Technical Note - Highways

Project: Rear of, 20, Halifax Road, Staincliffe, Batley, WF17 7BH

Date: 6th March 2026

1.1.1 This technical note provides a detailed response to comments raised by Kirklees Council (KC) for:

**DRAWING REF:** 25328-D02 **REV:** A

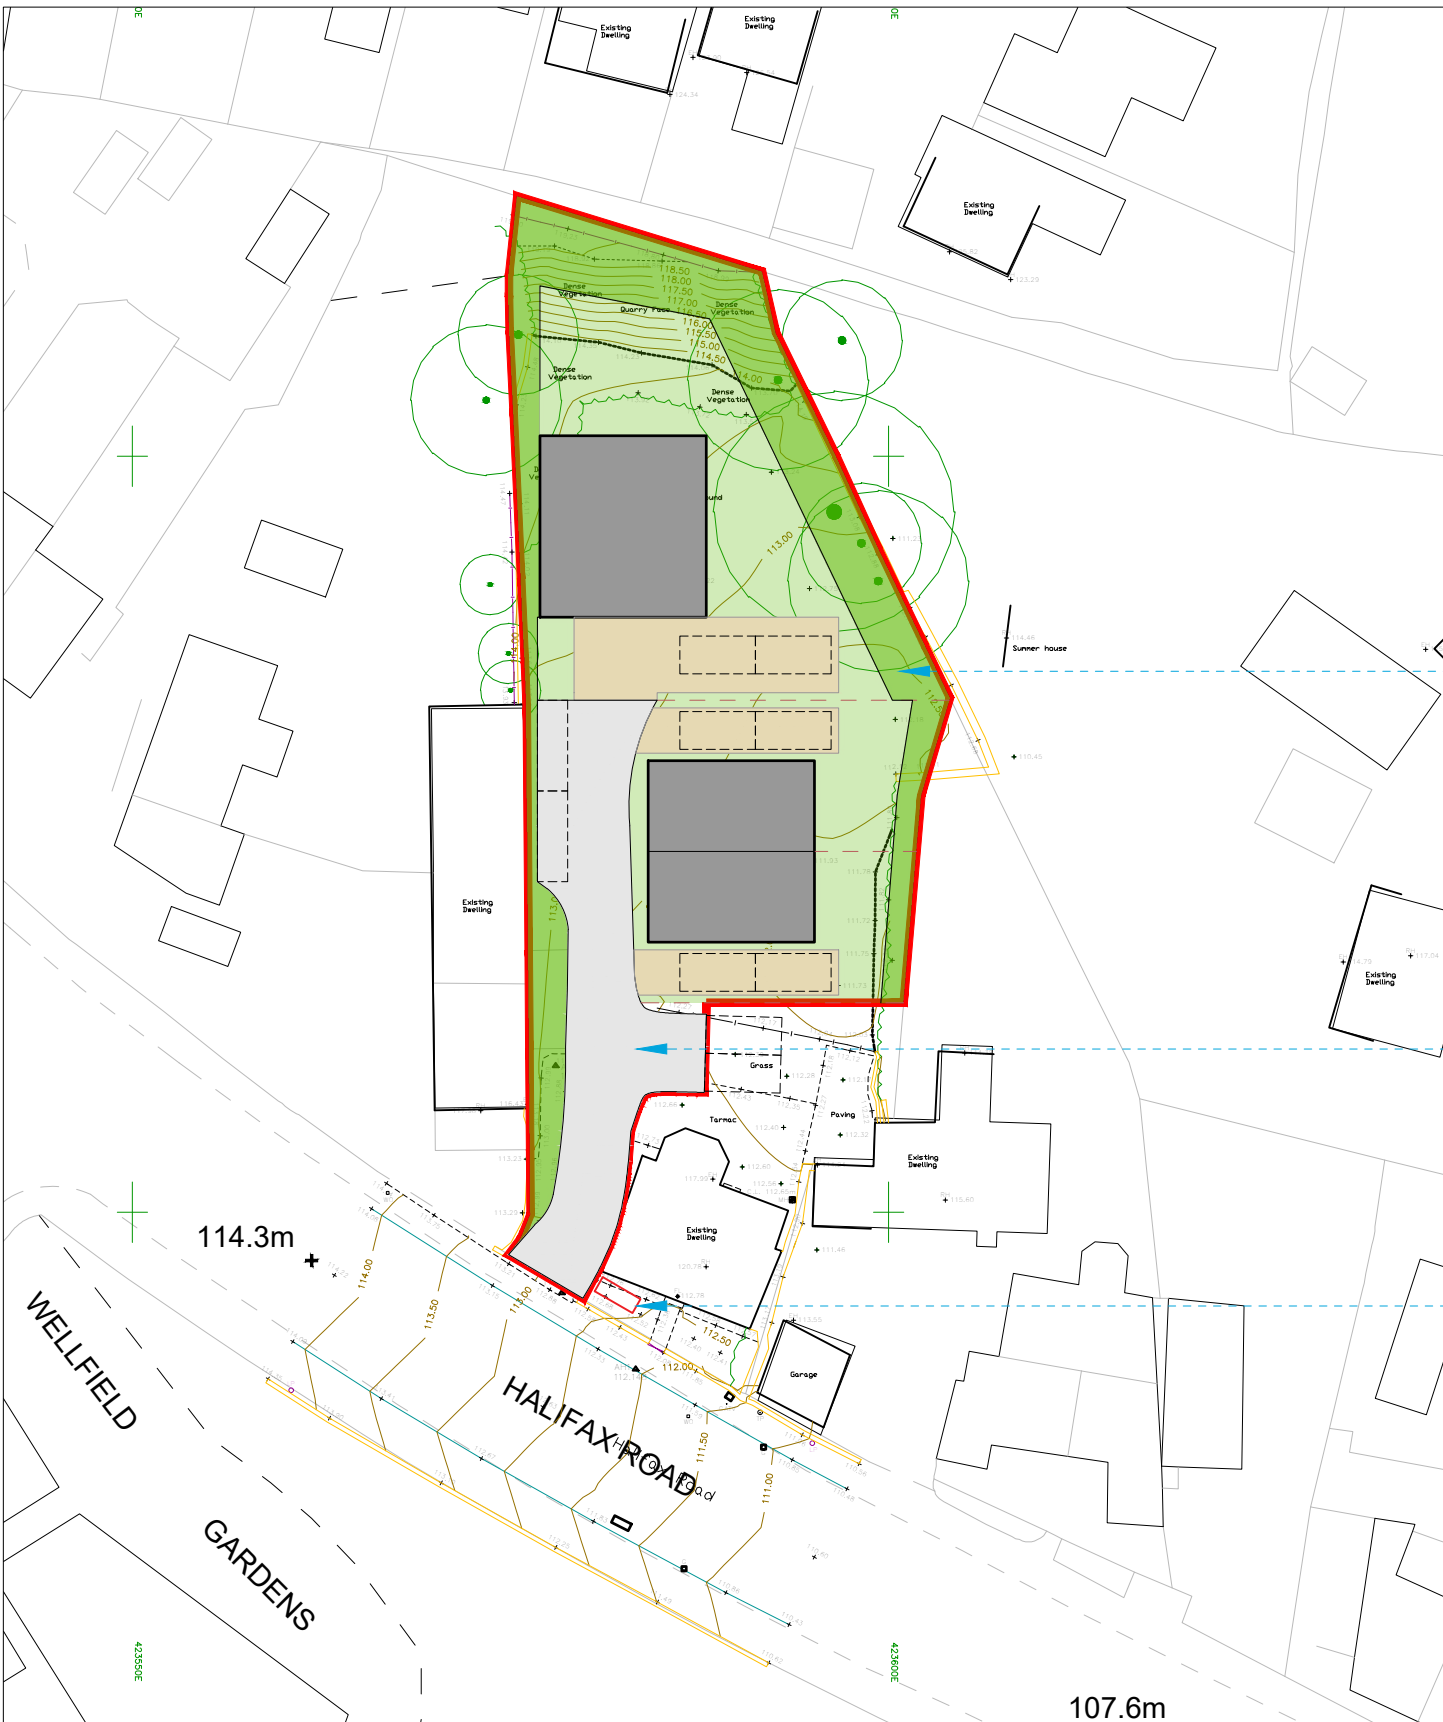
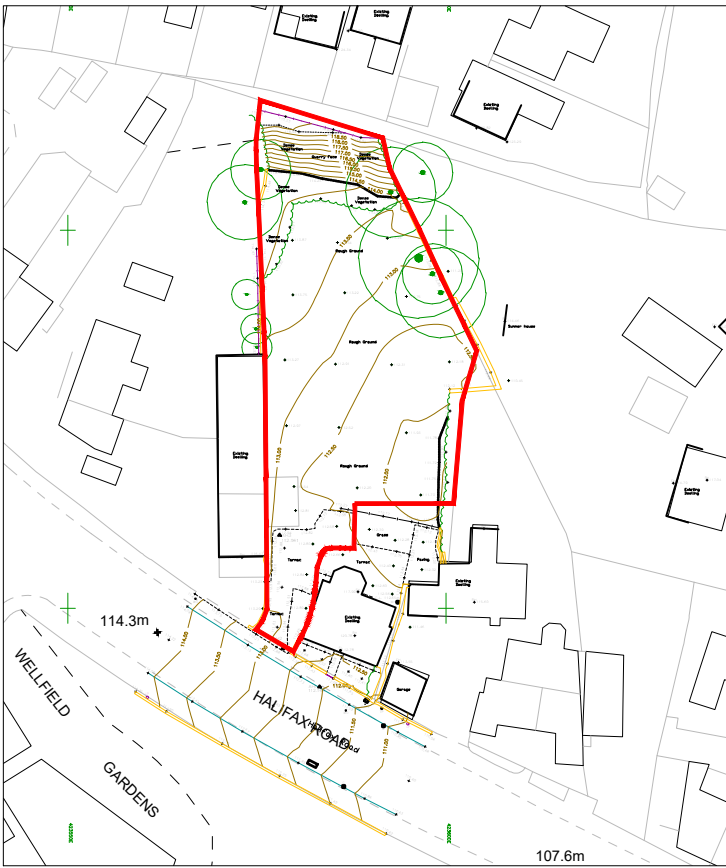
- 1.1.5 In regards to the internal layout, tracking for cars and a transit van has been carried out. The site layout has been amended to ensure that all the parking spaces are easily and safely accessible and that vehicles can turn within the site so that they can enter and exit the site in forward gear.
- 1.1.6 **Appendix C** provides the tracking drawing.
- 1.1.7 8 car parking spaces are proposed with **Appendix D** providing the revised site layout.
- 1.1.8 An updated Stage 1 RSA is to be carried out and the RSA Brief is provided in **Appendix E**.

REV A 03/04/2025 PLANNING ISSUE
 REV B 06/03/2026 ACCESS ROAD
 LAYOUT AMENDED
